Drainage Report Comments 2.pdf Markup Summary

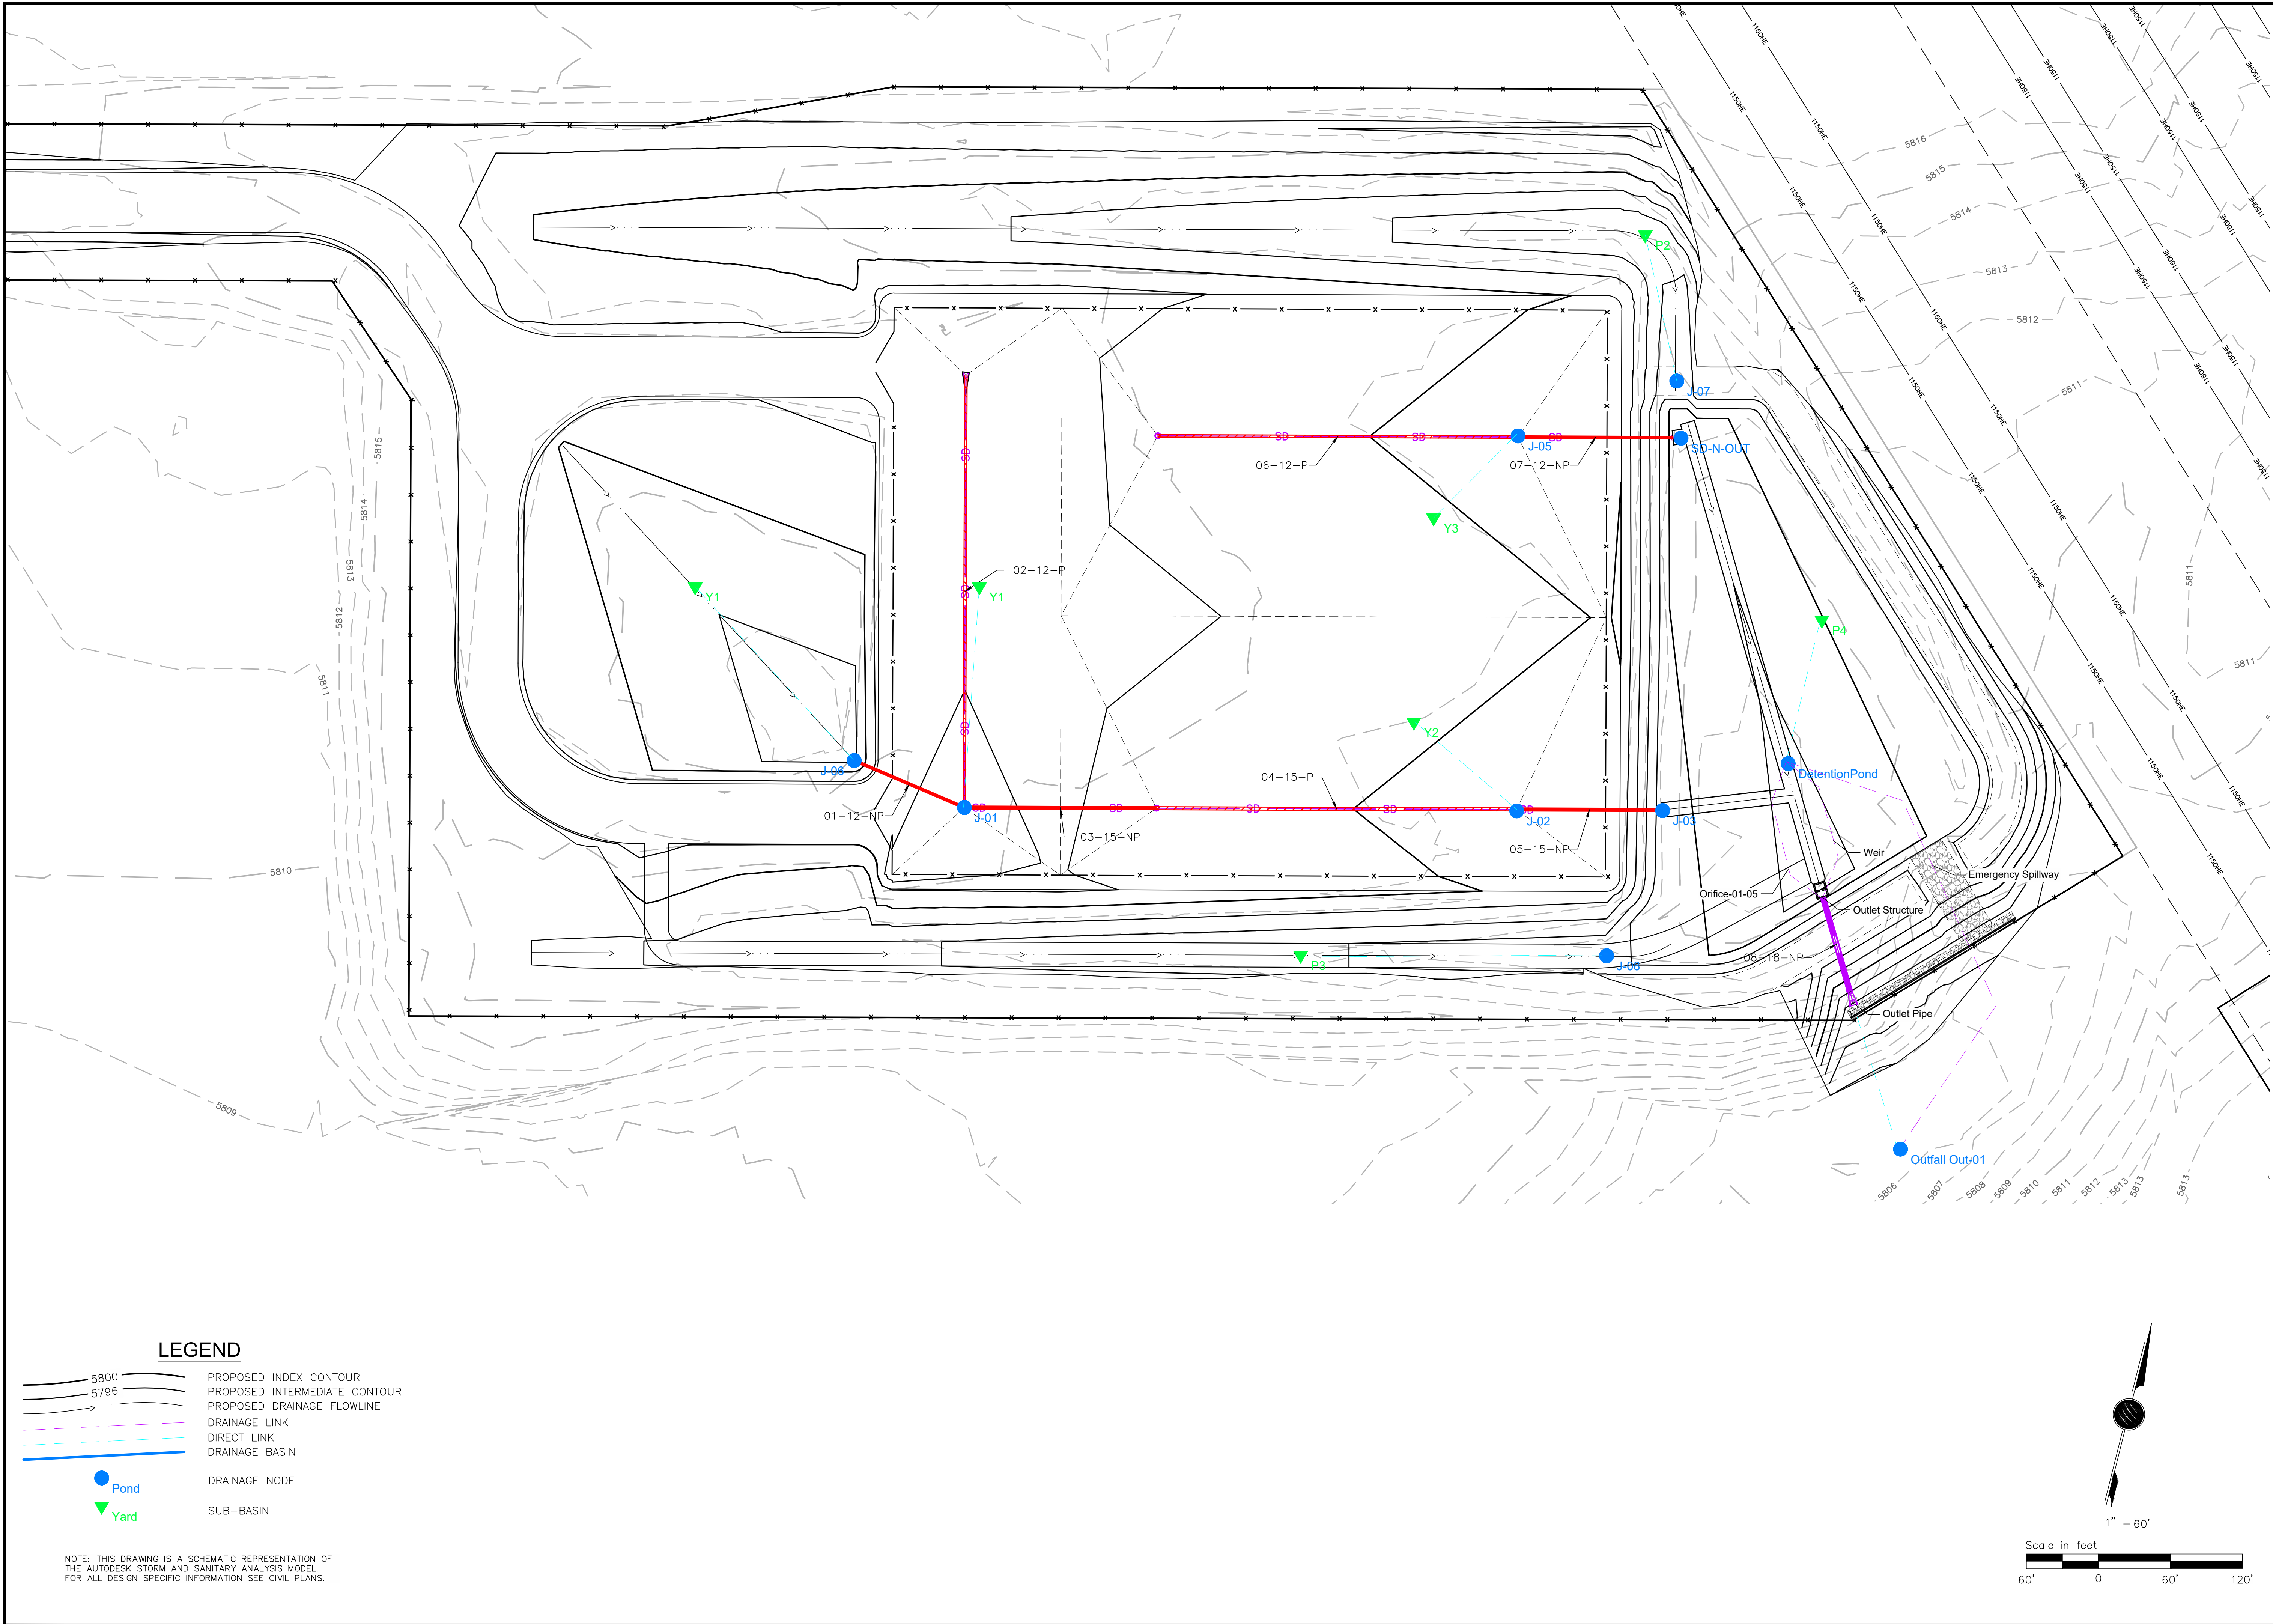
Unresolved:
Add Basin summary table

Are these meant to be labeled as the same swales? Per calculations in appendix north and south swales are riprap lined, please show swales hatched with riprap

Unresolved:
Label level spreader

Unresolved:
Label pond and all parts of the pond

DMC RESPONSE: Additional table added which includes area, disturbed area, weighted percent impervious, 5-year weighted runoff coefficient, 100-year weighted runoff coefficient

DMC RESPONSE: The southern swale was mis-labeled and has been corrected. The northern swale is grass lined. The calculations for the swale rundown riprap have been re-named and notes have been added to clarify that they are for the rundowns, and not the entirety of the swale.

DMC RESPONSE: Level spreader labeled

DMC RESPONSE: Pond, trickle channel, outlet structure, and emergency spillway labeled
